REFUSAL OF PLANNING PERMISSION

APPLICATION NO. 2017/0522

Proposal Erection of extensions to side and rear of dwelling and two storey side extension to existing garage

At 2 The Green, Thurlstone, Barnsley, S36 9QG

PLAN & ELEVATIONS

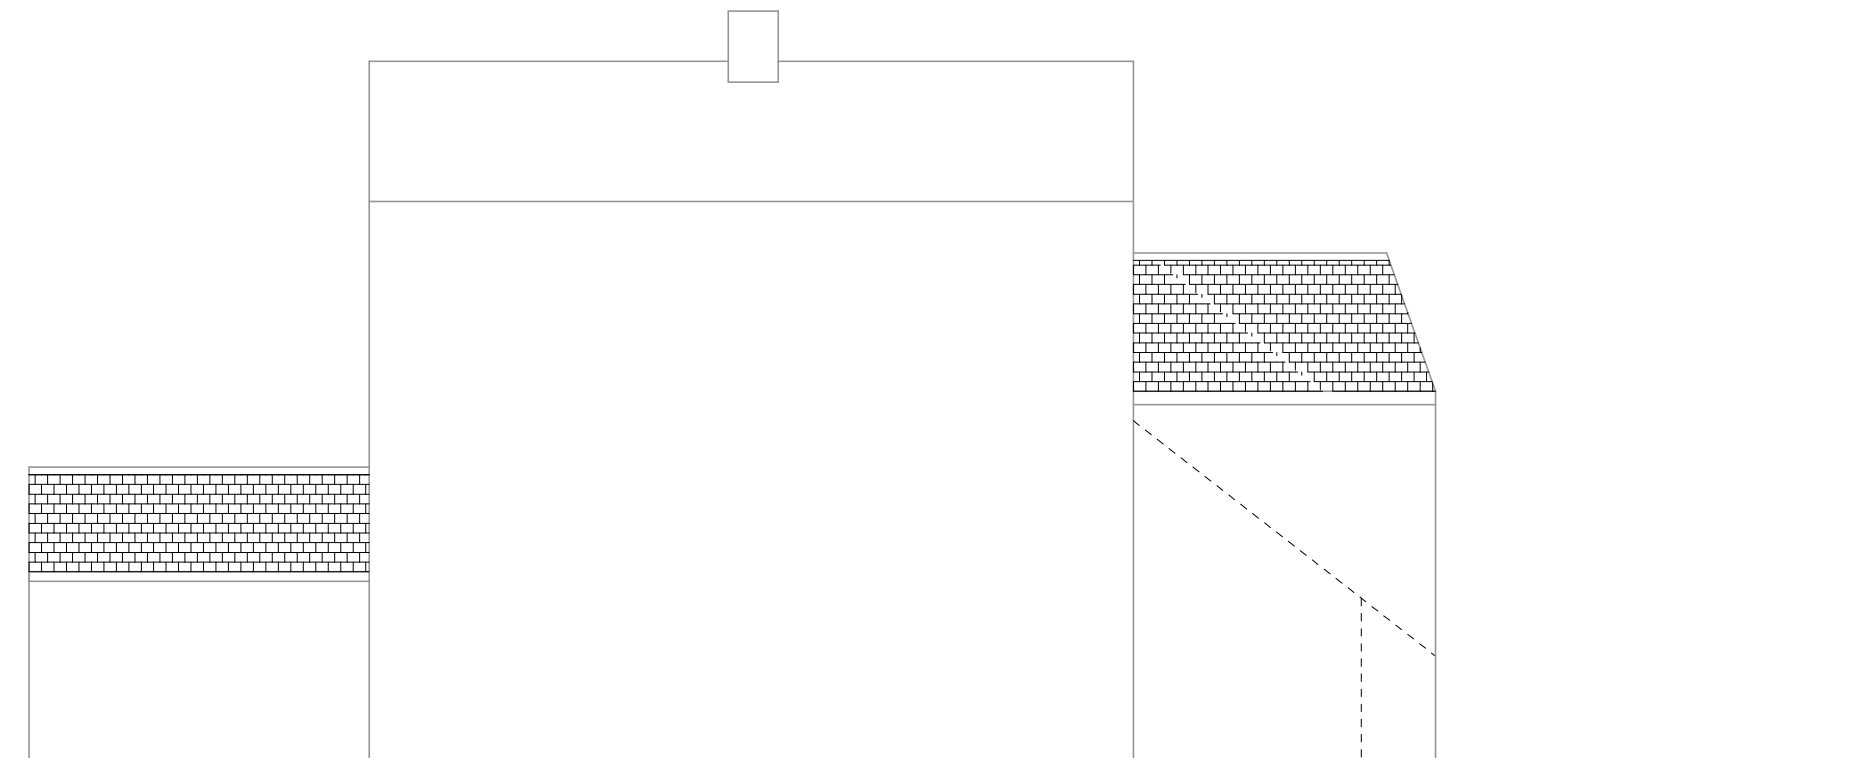
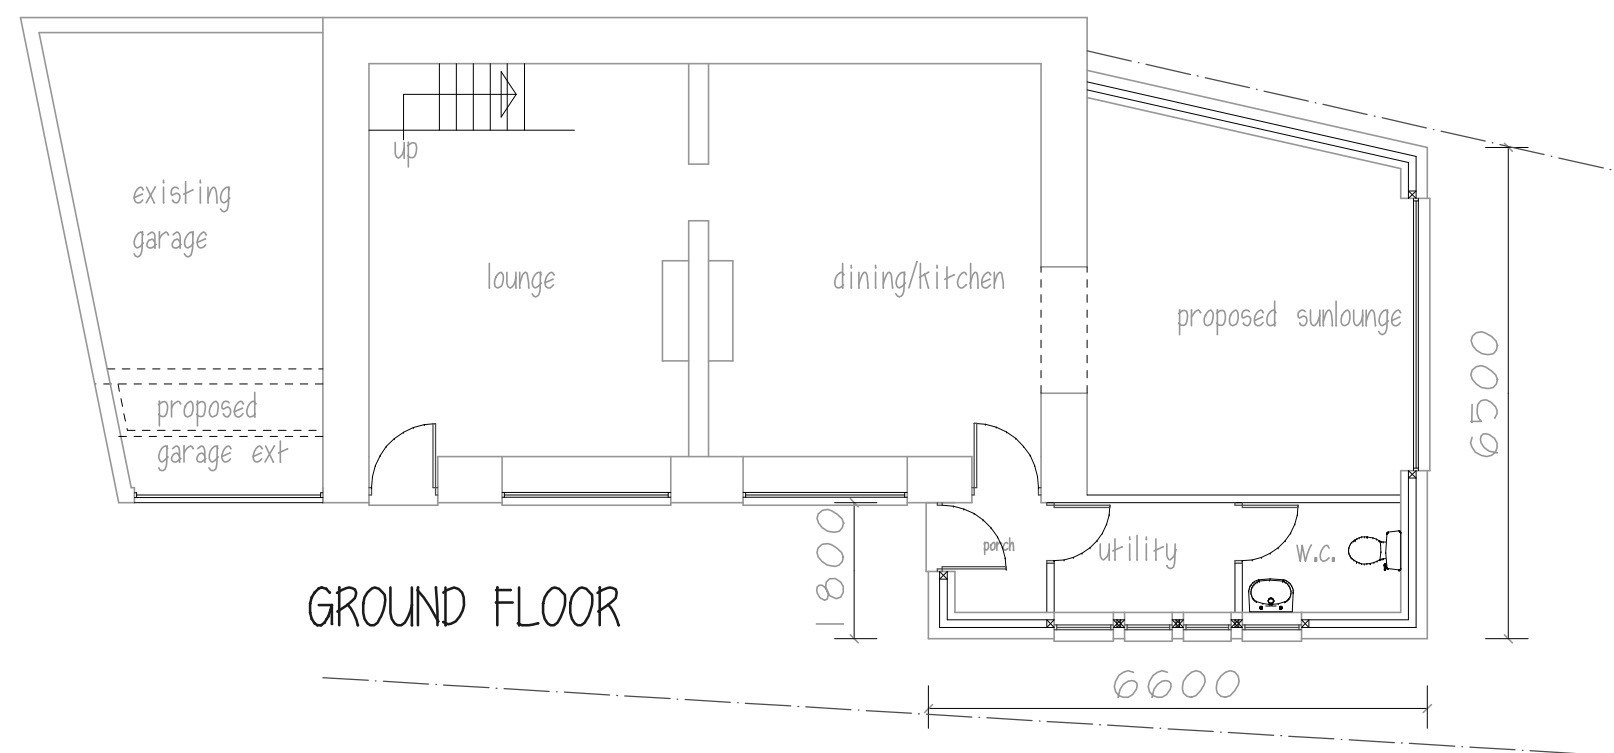
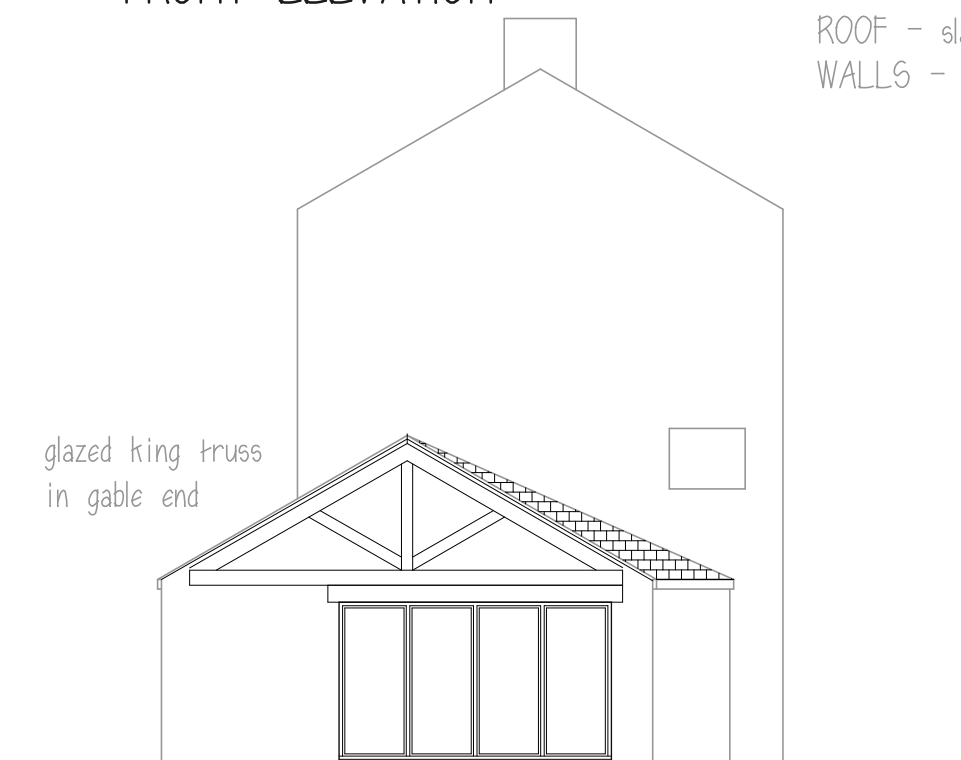
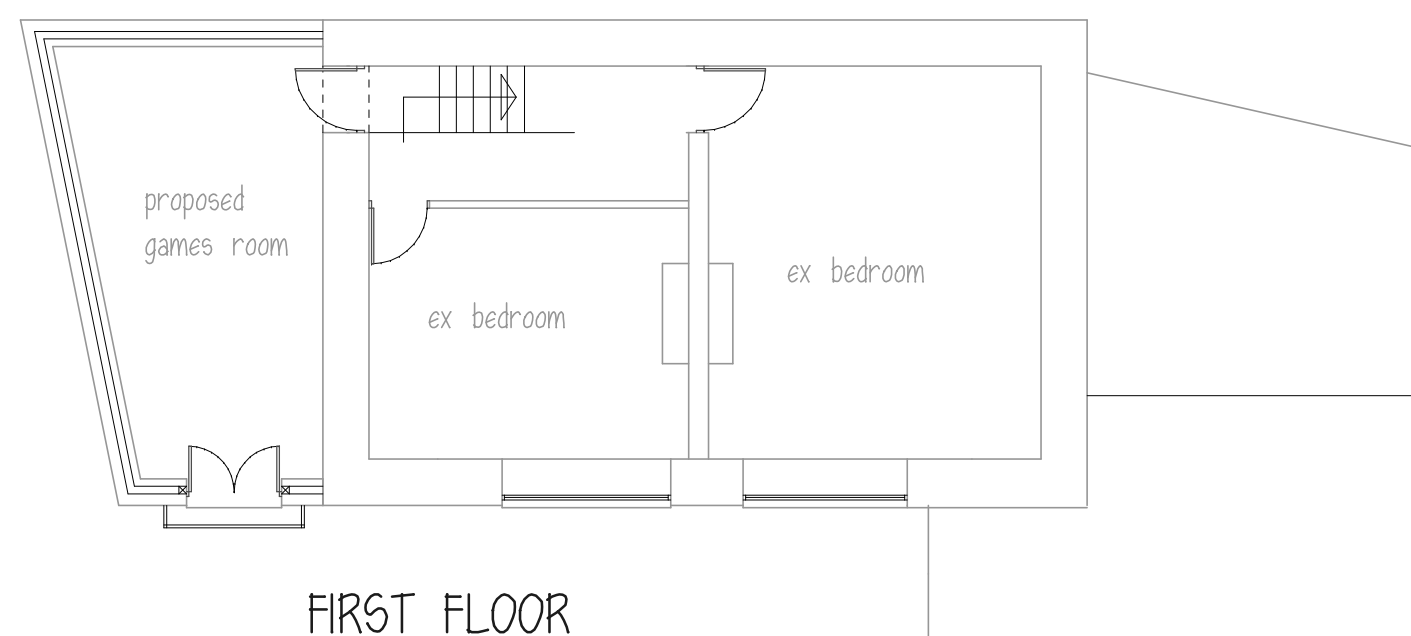
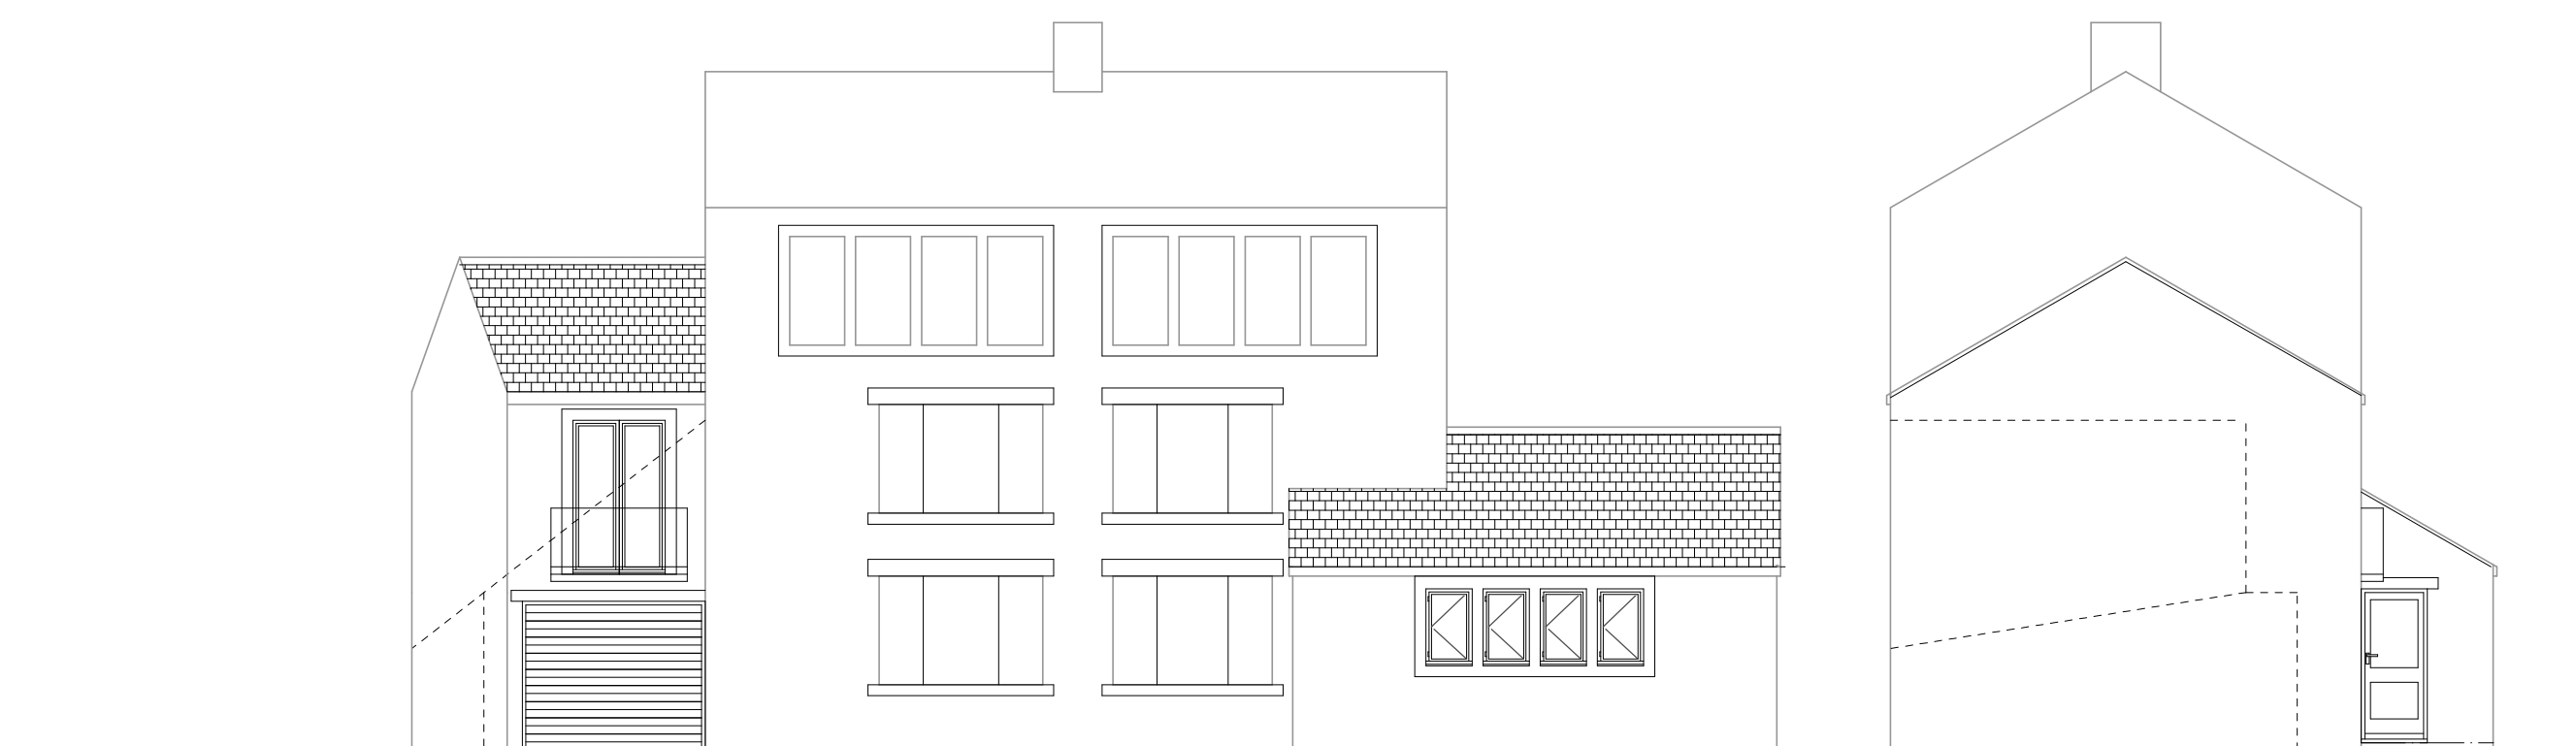
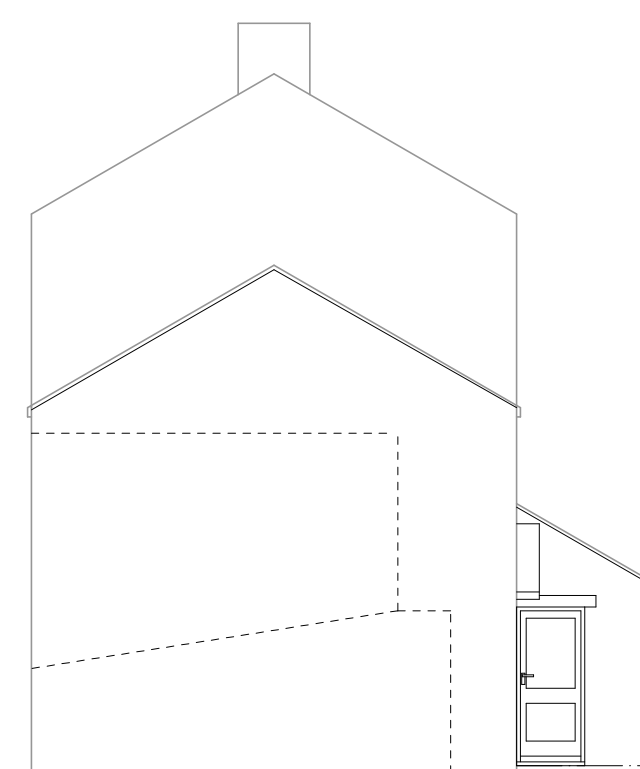
- 1 In the opinion of the Local Planning Authority the proposed two storey side extension would be contrary to Core Strategy Policy 30: The Historic Environment, Core Strategy Policy 29: Design Principles, and the Council's Supplementary Planning Document House Extensions, in that its design would be architecturally inconsistent with the character of the property and the Conservation Area, and would as a consequence appear as an unduly intrusive feature in the street scene to the detriment of visual amenity.
